Ribble Valley Borough Council  
Housing & Development Control

Application no: **3/2019/0648**

Address: **34 Painter Wood Whalley Old Road Billington BB7 9JD**

Proposal: **Demolition of existing dwelling house and erection of a replacement dwelling house with associated external works. Resubmission of planning permission 3/2019/0297**

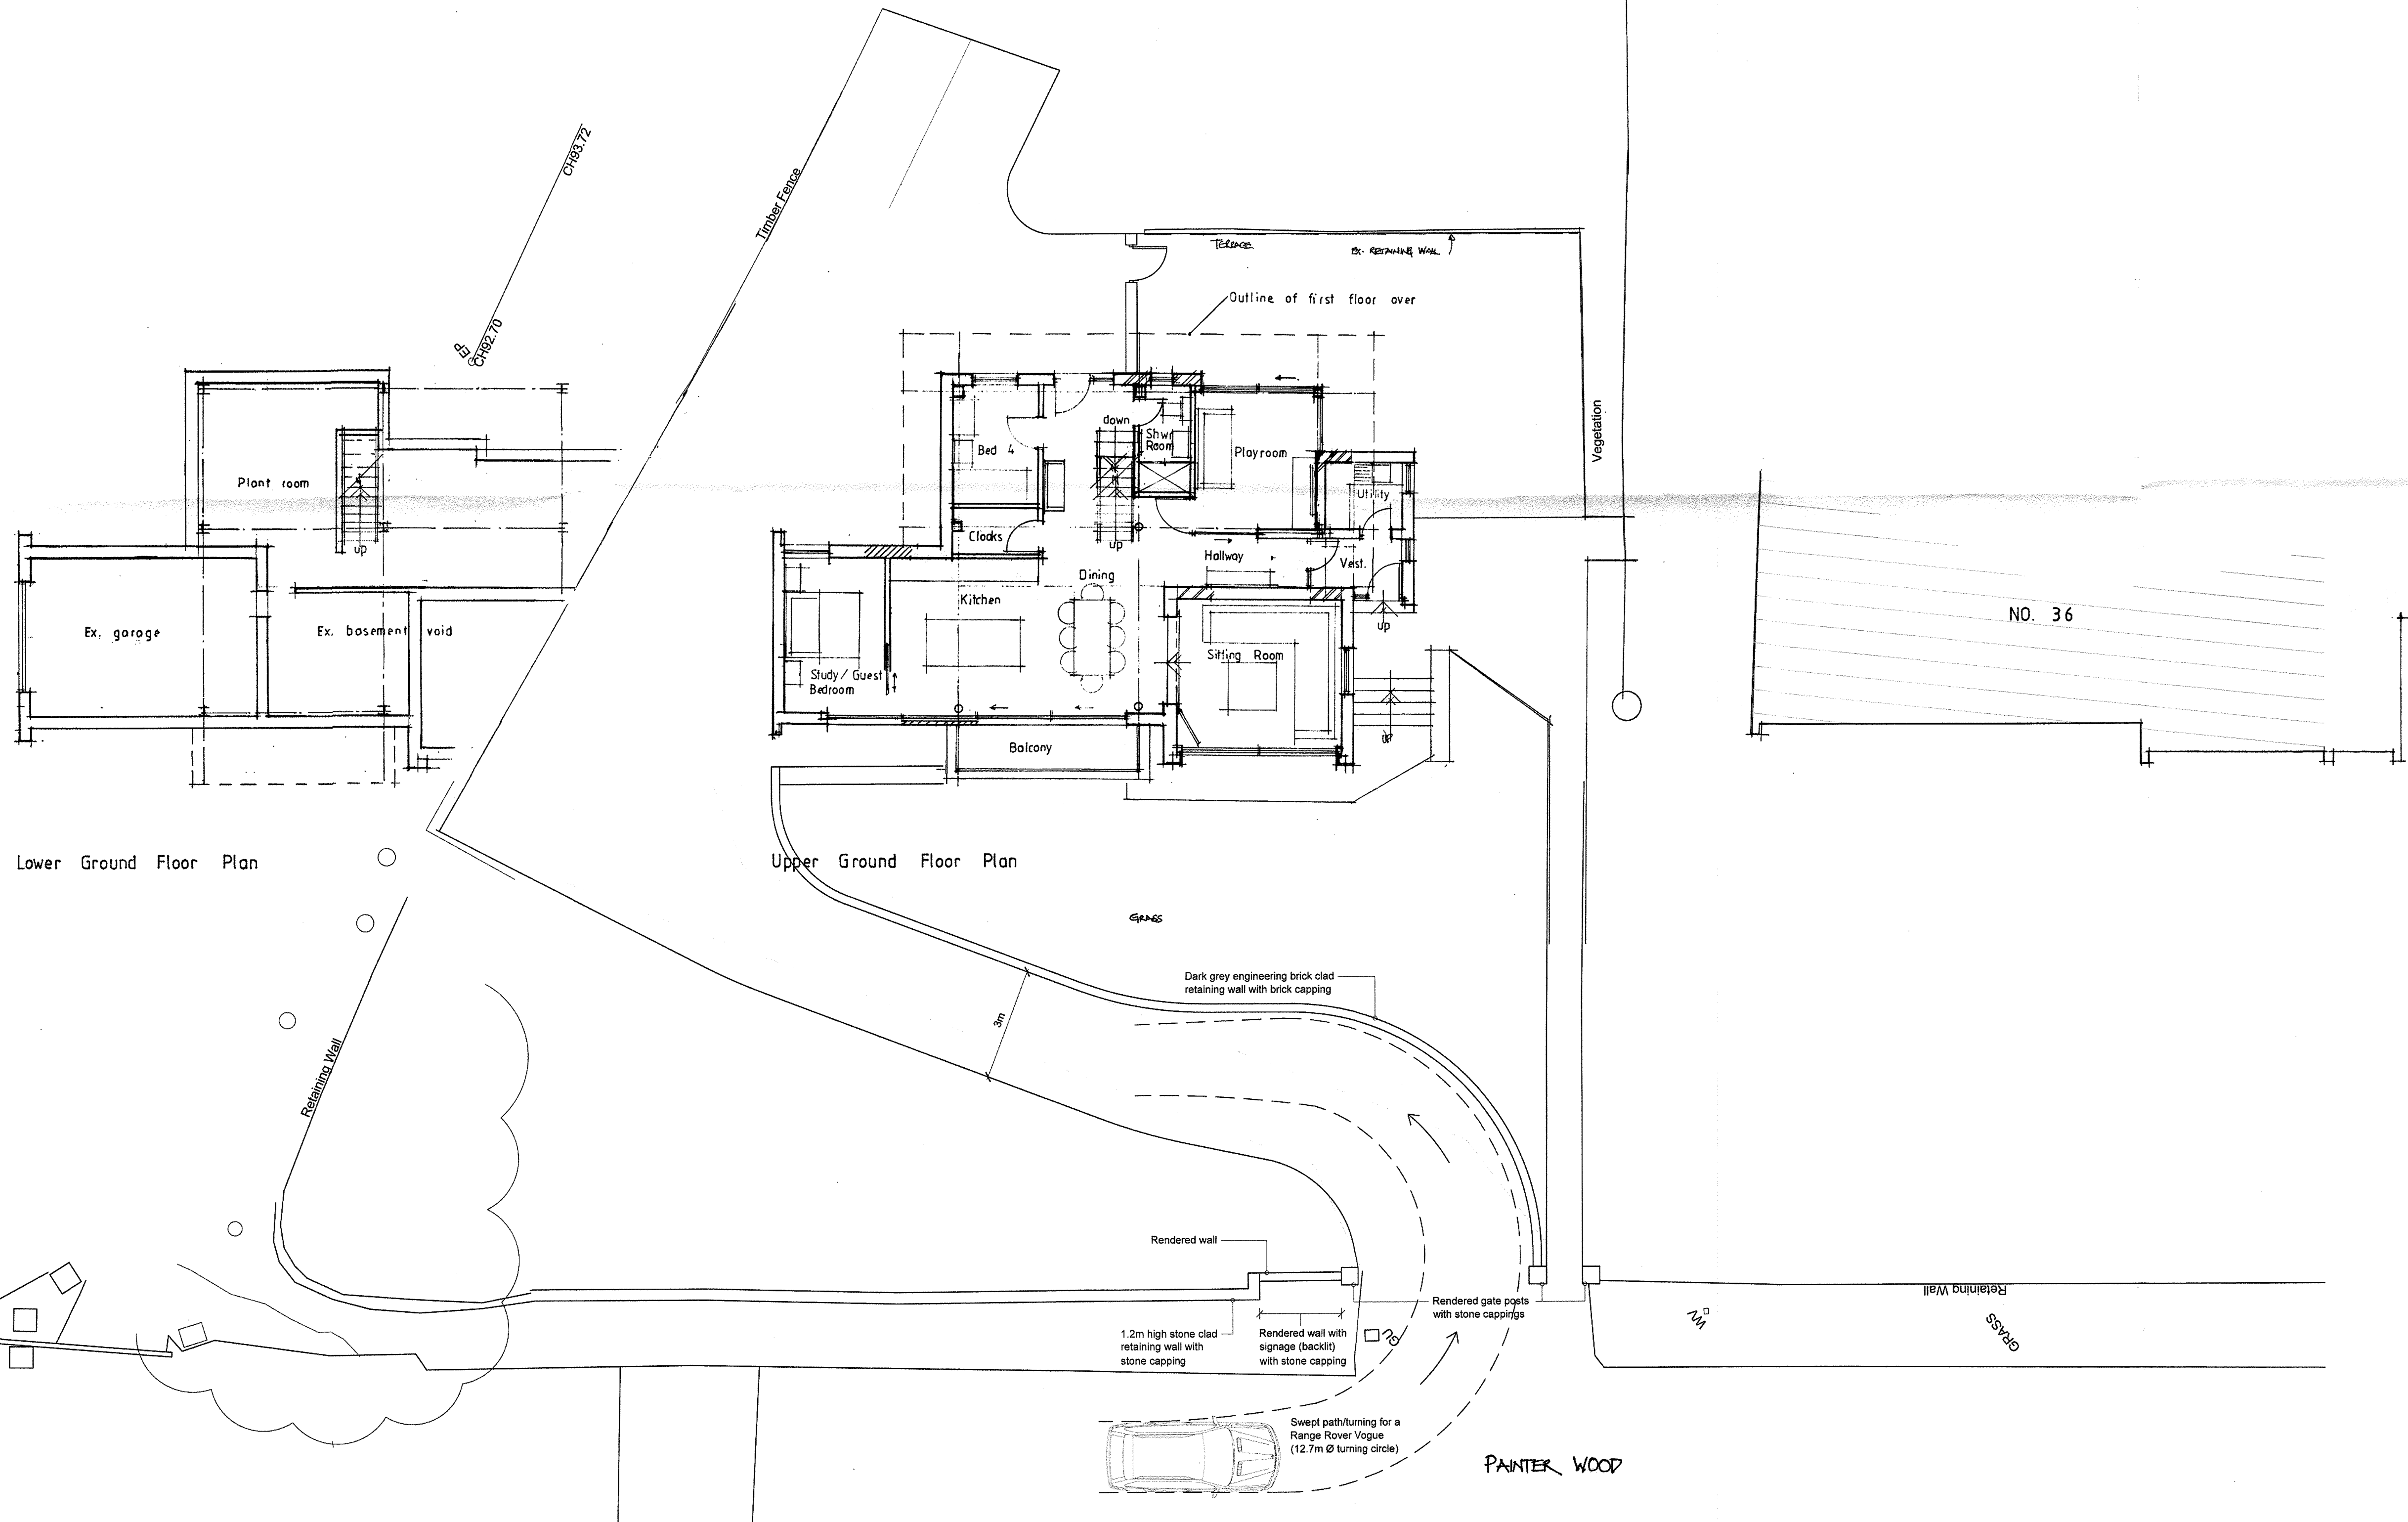
In accordance with the proposed site plan, drawing number 5744-10D the plans demonstrate the proposal of a 1.2m high boundary treatment wall fronting the application site. However, the boundary wall shall be no greater than 1.05m in height to aid visibility and safe access to and from the proposed dwelling.

- A scheme for recycling/disposing of waste resulting from demolition and construction works
  - Routing of delivery vehicles to/from site
2. Notwithstanding the provisions of the Town and Country Planning (General Permitted Development) Order 1995 there shall not at any time in connection with the development hereby permitted be erected or planted or allowed to remain upon the land hereinafter defined any building, wall, fence, hedges, trees, shrubs or other devices over 1.05m above road level. **Reason:** To ensure adequate visibility at the street junction or site access.
